From: Juan Baeza
Sent: 15 September 2011 16:47
To: Planning.Responses
Subject: FW: Greenoaks, Barnham EG/33/11 scheme

From: Ian Brewster
Sent: Thu 15/09/2011 16:00
To: Juan Baeza
Subject: Greenoaks, Barnham EG/33/11 scheme

With regard to the above scheme, the proposed access from the Barnham Road to the rear of the development site will require the removal of prominent trees, a group of Hornbeams T3 & G4 and individual Silver Birch T14. These can clearly be seen from Barnham Road, and provide good visual amenity and should be retained.

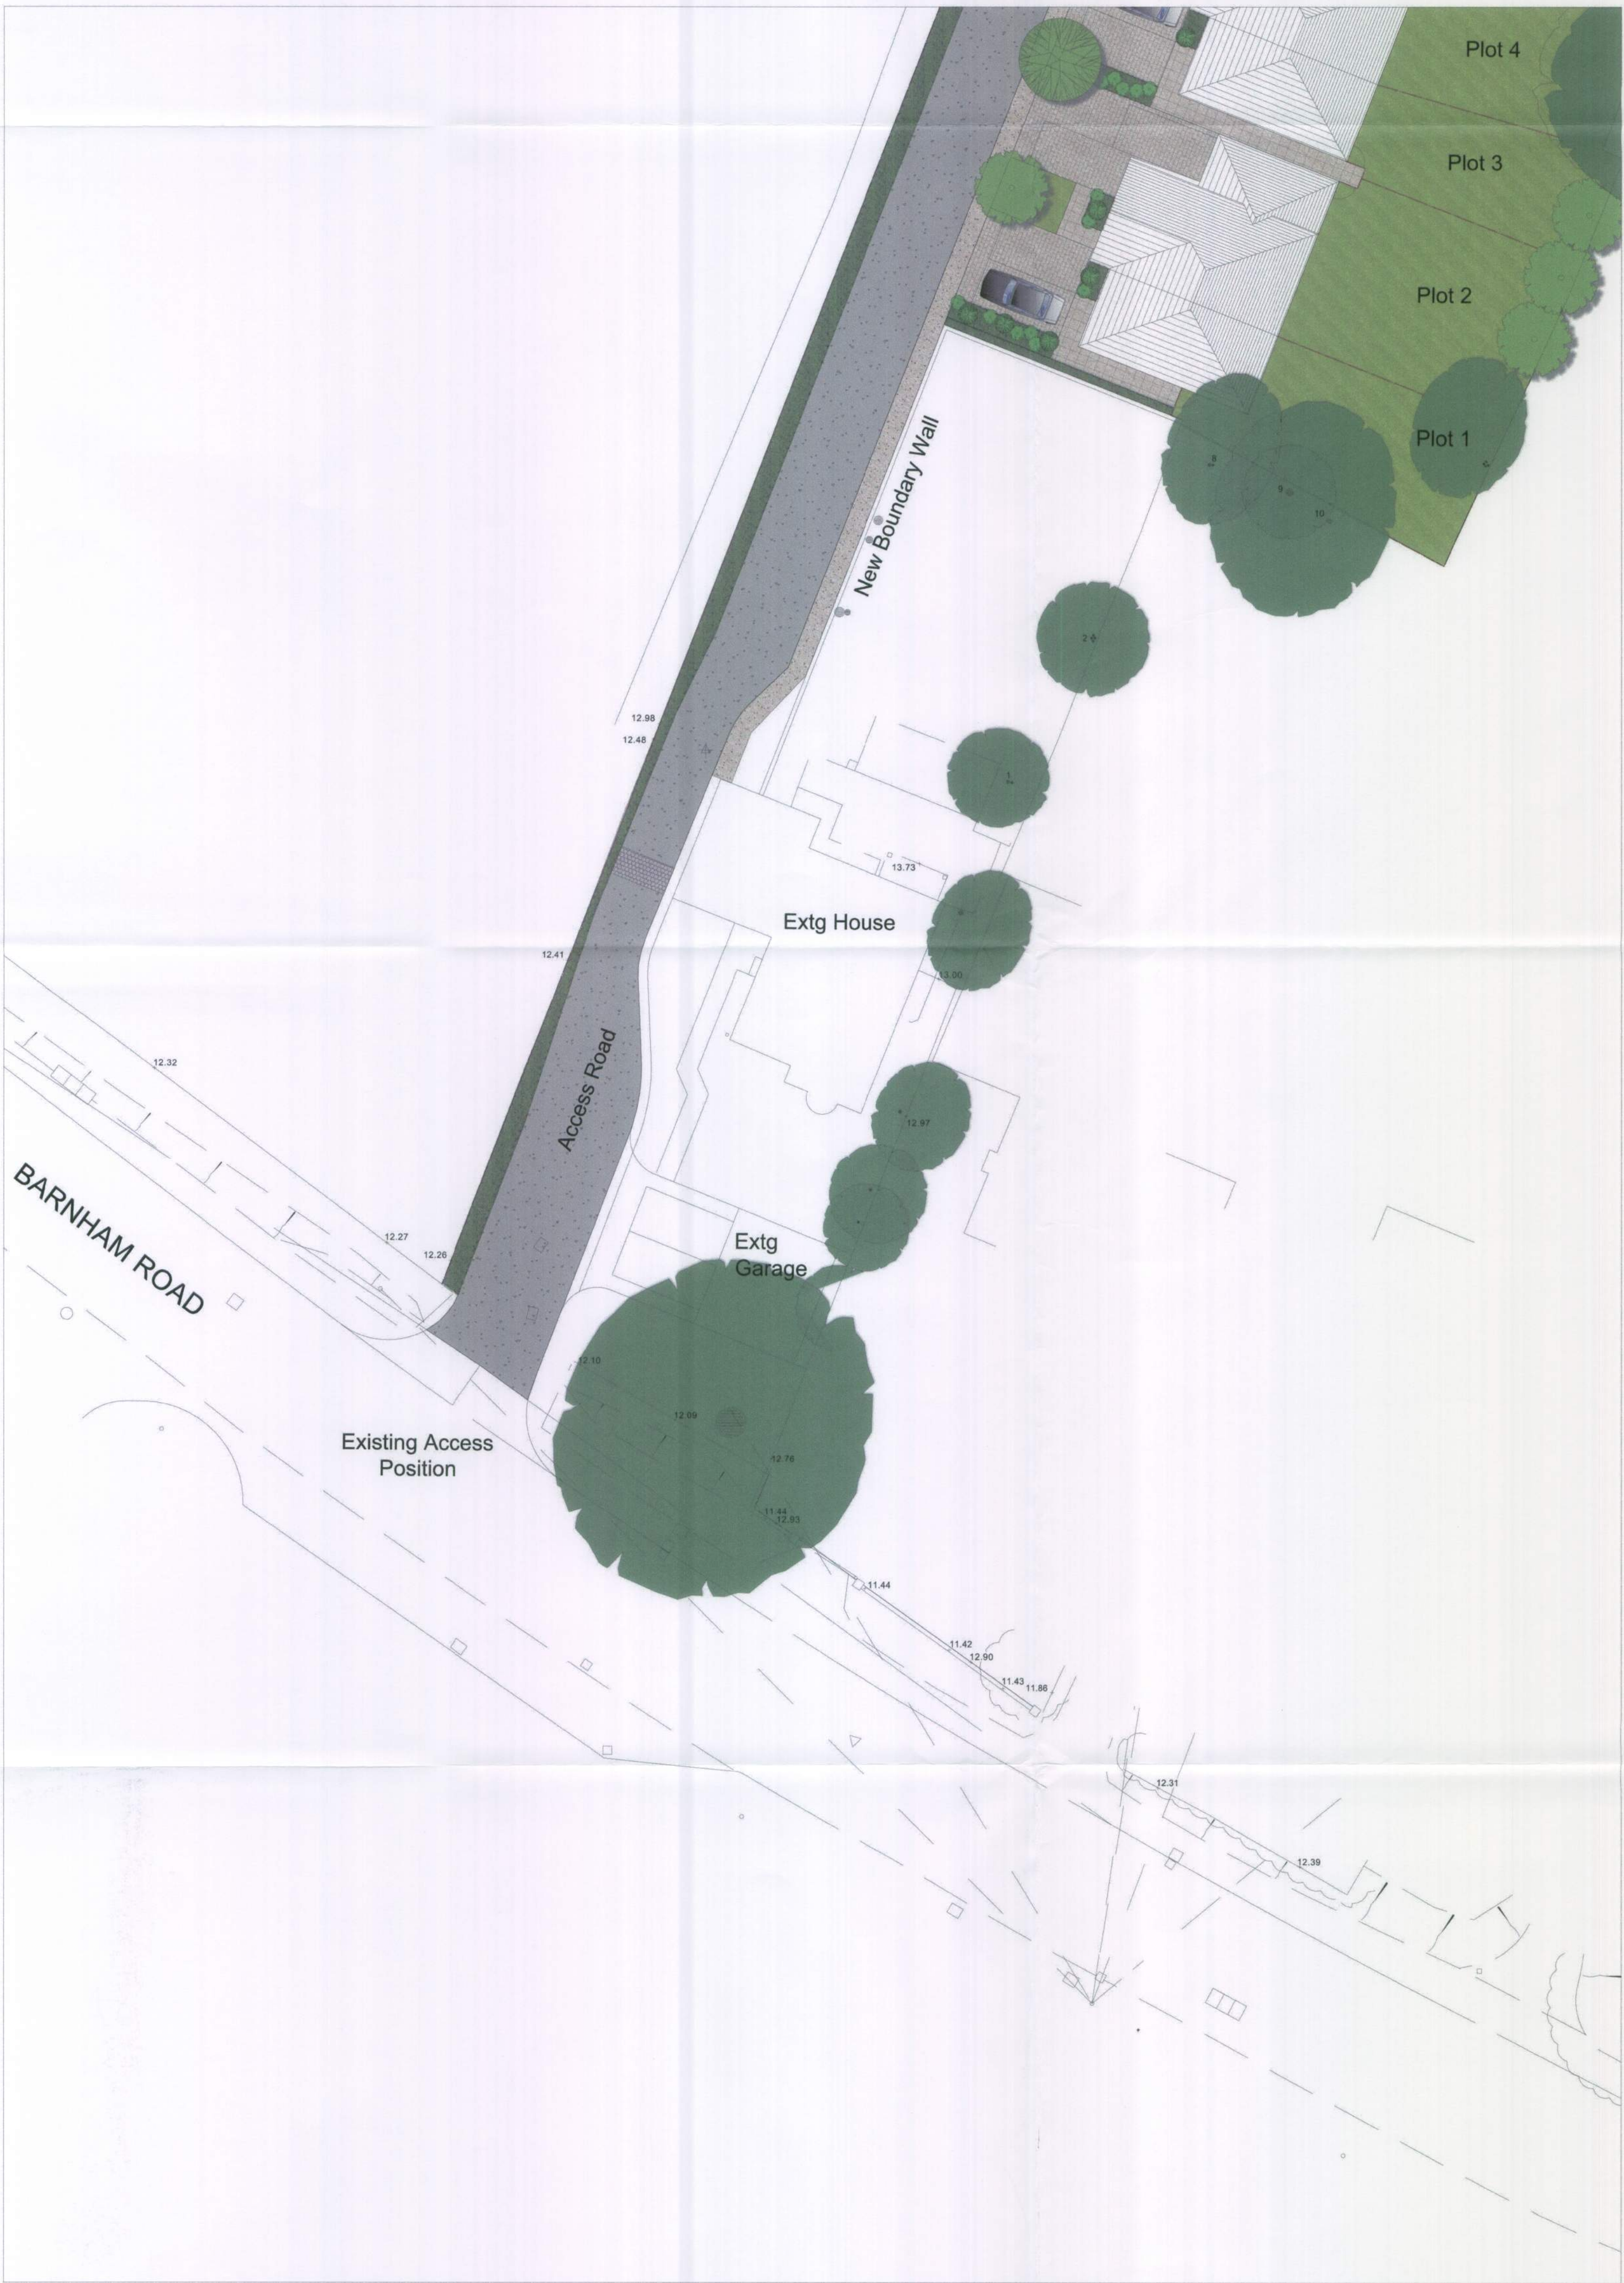
The loss of many trees within the site can be compensated as replacement planting within the space provided where the conifer screen is to be removed. A range of Indigenous species, of good quality, with some low shrubbery (Dog Rose, Wayfaring tree etc) is recommended. Adequate space for planting should therefore be provided in a staggered fashion within a width measuring 4m from the south west boundary. This will provide a natural, informal than an otherwise regimented line of trees and shrubbery along this boundary.

Natural England have been contacted and they state that the removal of the conifer screen should not affect Bats if compensatory planting will immediately supersede their loss. Stumps may require removal and all conifer foliage/chip arisings must be removed and replaced with quality multi purpose topsoil, with an approved ameliorant in compliance with the specifications outlined in the BS 3882 standard to provide an appropriate area for the successful establishment of planting stock.
